Appeal Decision

Appeal Ref: 6004329

14 Willow Tree Lane, Hayes, Hillingdon UB4 9BB

- The appeal is made under section 78 of the Town and Country Planning Act 1990 (as amended) against a refusal to grant planning permission.
 - The appeal is made by Sunny Singh against the decision of the Council of the London Borough of Hillingdon.
 - The application Ref is 5516/APP/2025/2441.
 - The development proposed is Change of use from Class C3 dwelling house to 7-bedroom/maximum 8 person HMO Use Class Sui Generis.
-

HD00257 - PL03

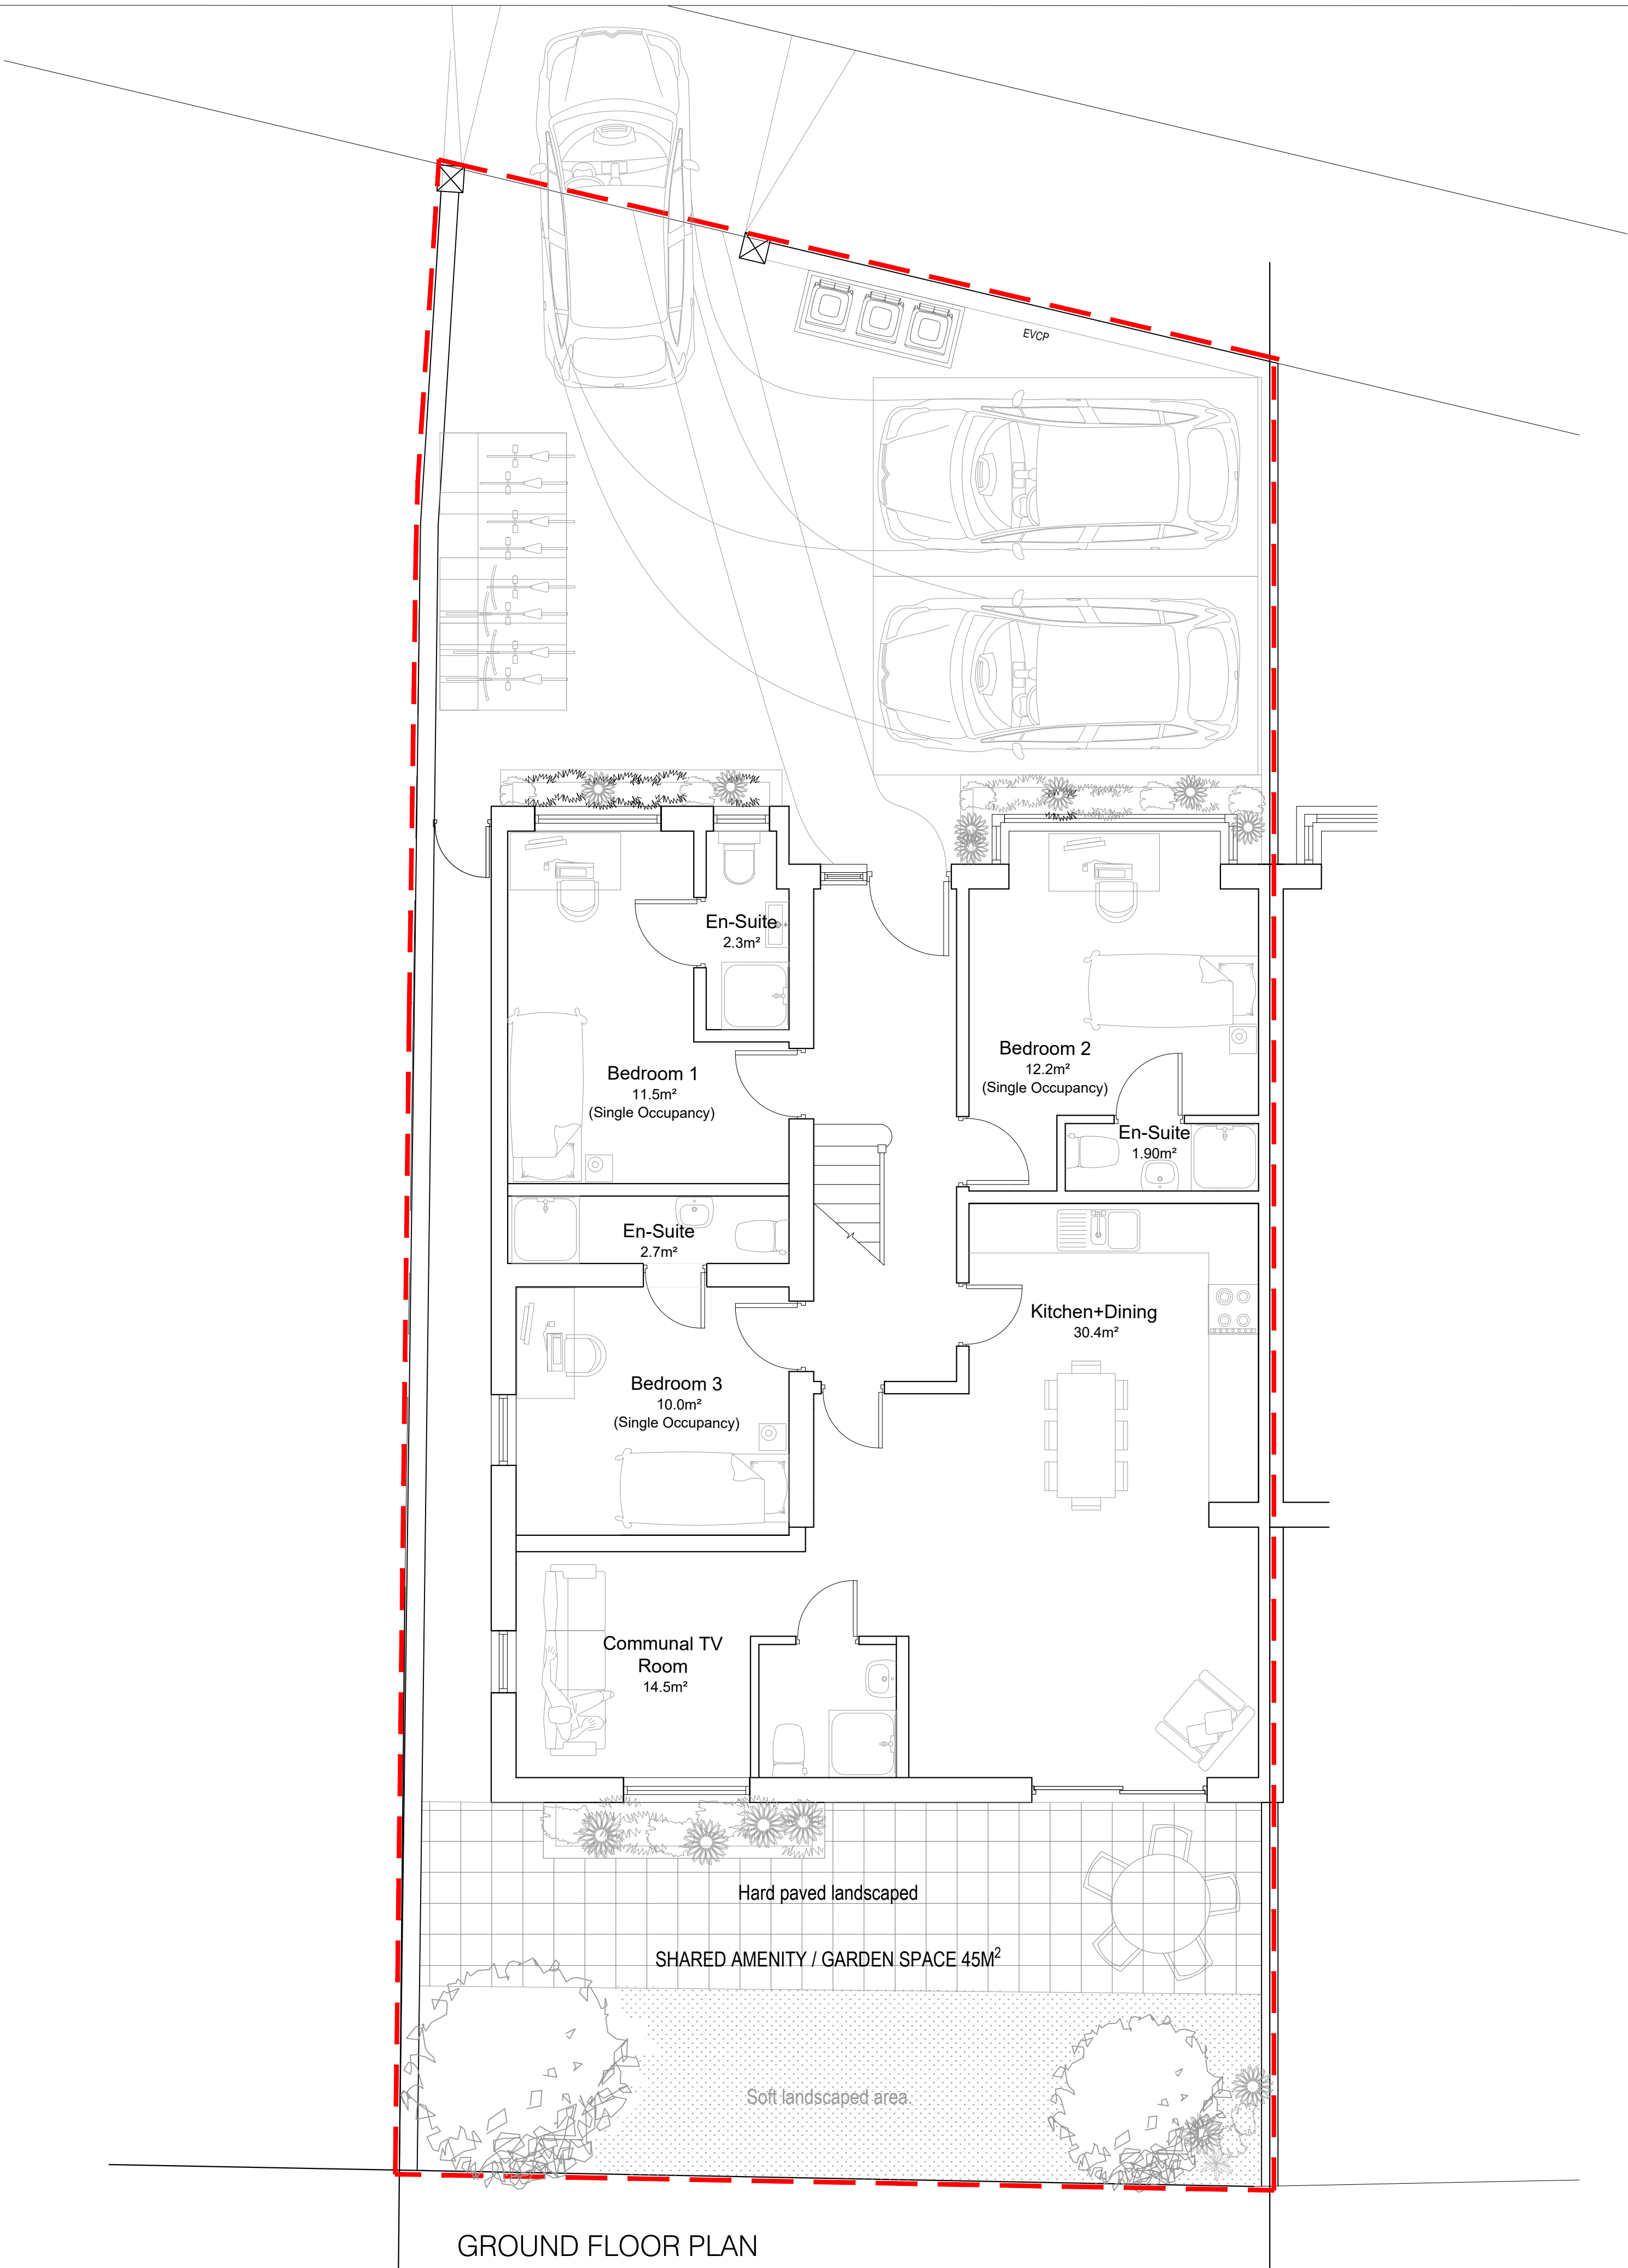
20. Three of the proposed bedrooms would be on the ground floor. One of those, identified as Bedroom 3, would be sandwiched between a front-facing bedroom and the rear kitchen extension. The only source of daylight would be the single side-facing window, which faces into a very narrow path between the appeal property and its unattached neighbour. On the other side of the path, very close to the window, is the blank brick wall of the neighbouring rear extension.

21. As a result of that relationship, the outlook from Bedroom 3 would be extremely enclosed, making for a gloomy and unappealing internal environment. While the occupier would also have access to communal areas, Bedroom 3 would be their only personal, private space and that aspect of the proposed layout fails to provide a suitable standard of accommodation for future occupiers.

26. Nevertheless, due to the poor outlook from Bedroom 3, I conclude that the proposal as a whole would not provide suitable living conditions for all future occupiers. That would conflict with the requirement in Policy DMH5 of the Part Two Local Plan that large HMOs provide satisfactory living conditions for the intended occupiers. However, the proposed living environment would otherwise generally accord with relevant design requirements in Policies DMHB11 and DMHB16, and the technical conflict with the outdoor amenity space standards in Policy DMHB18 is outweighed by other material considerations.
